**Consultation Response from KC,
Highways Development Management**

2024/92548 40, Bradford Road, Fartown, Huddersfield, HD1 6JE

Change of use of dwelling to 10 bed House of Multiple occupation including erection of 3 storey extension and associated alterations'

Date Responded: 6-1-2025.

Drawing Title:
PROPOSED FLOORS PLANS

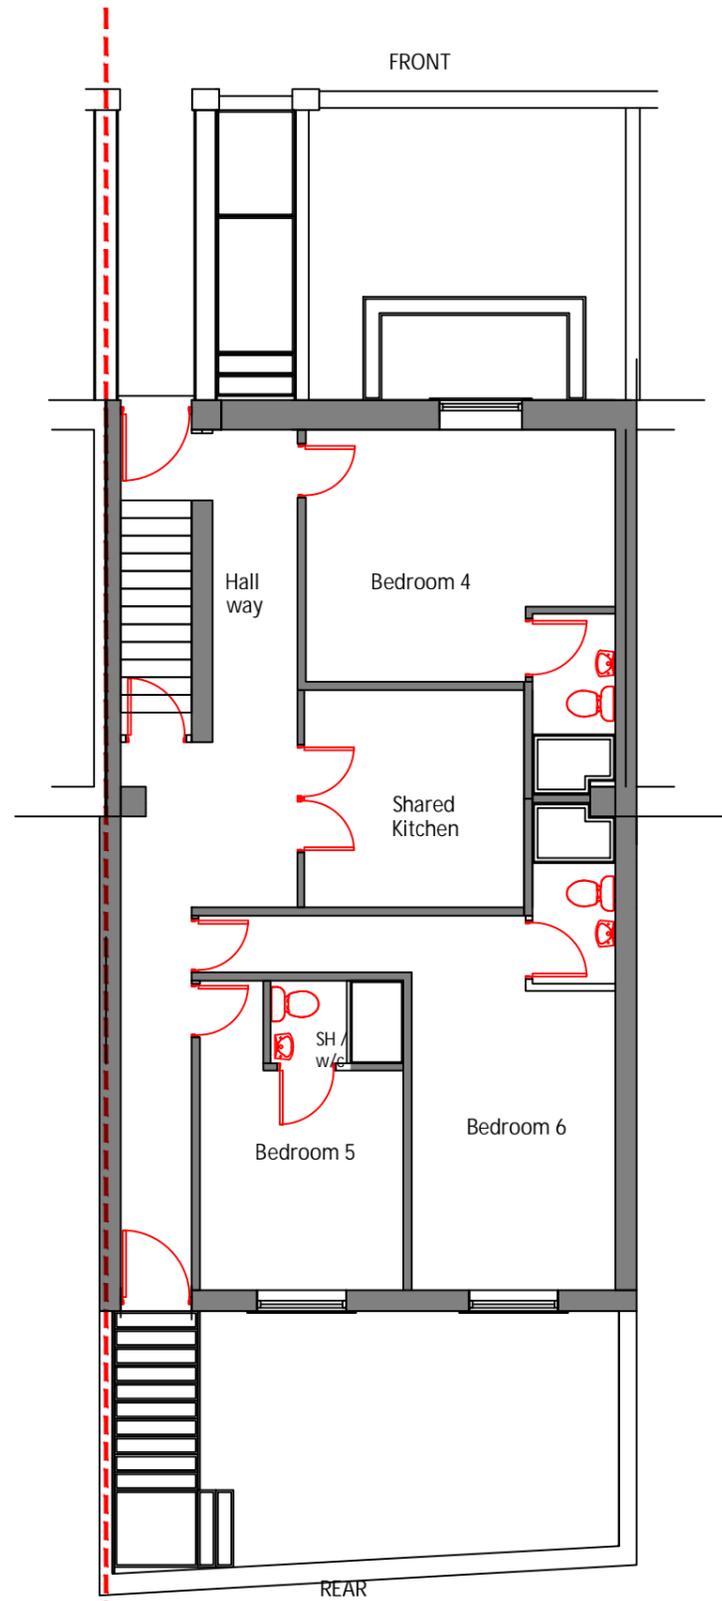
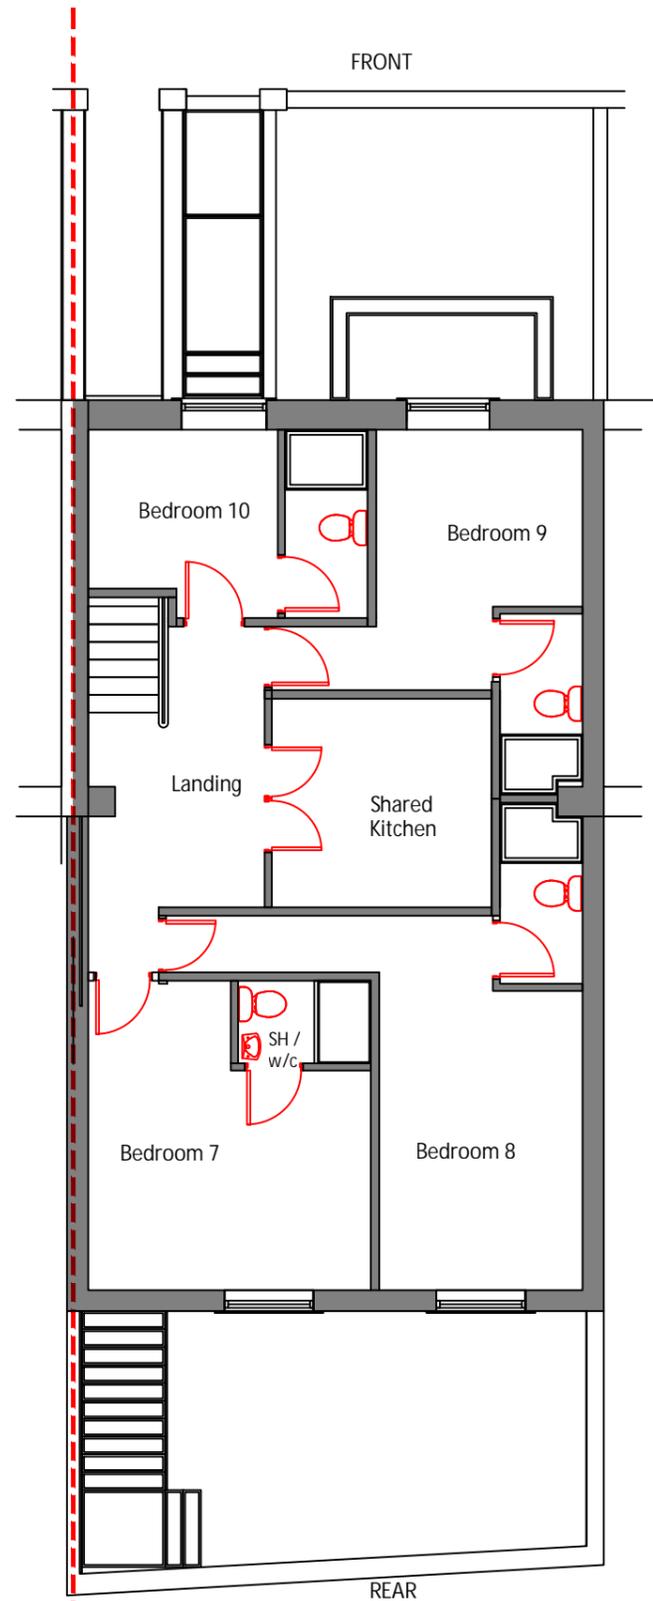
There are however no proposals provided for the storage and collection of wastes from the site.

HDM would not wish to see bins stored or collected from the Bradford Road footway.

Details of the proposals for the storage and collection of wastes from the site should be provided. A bin collection point should be shown to be provided to enable bins to be presented on collection day without obstructing the Bradford Road footway.
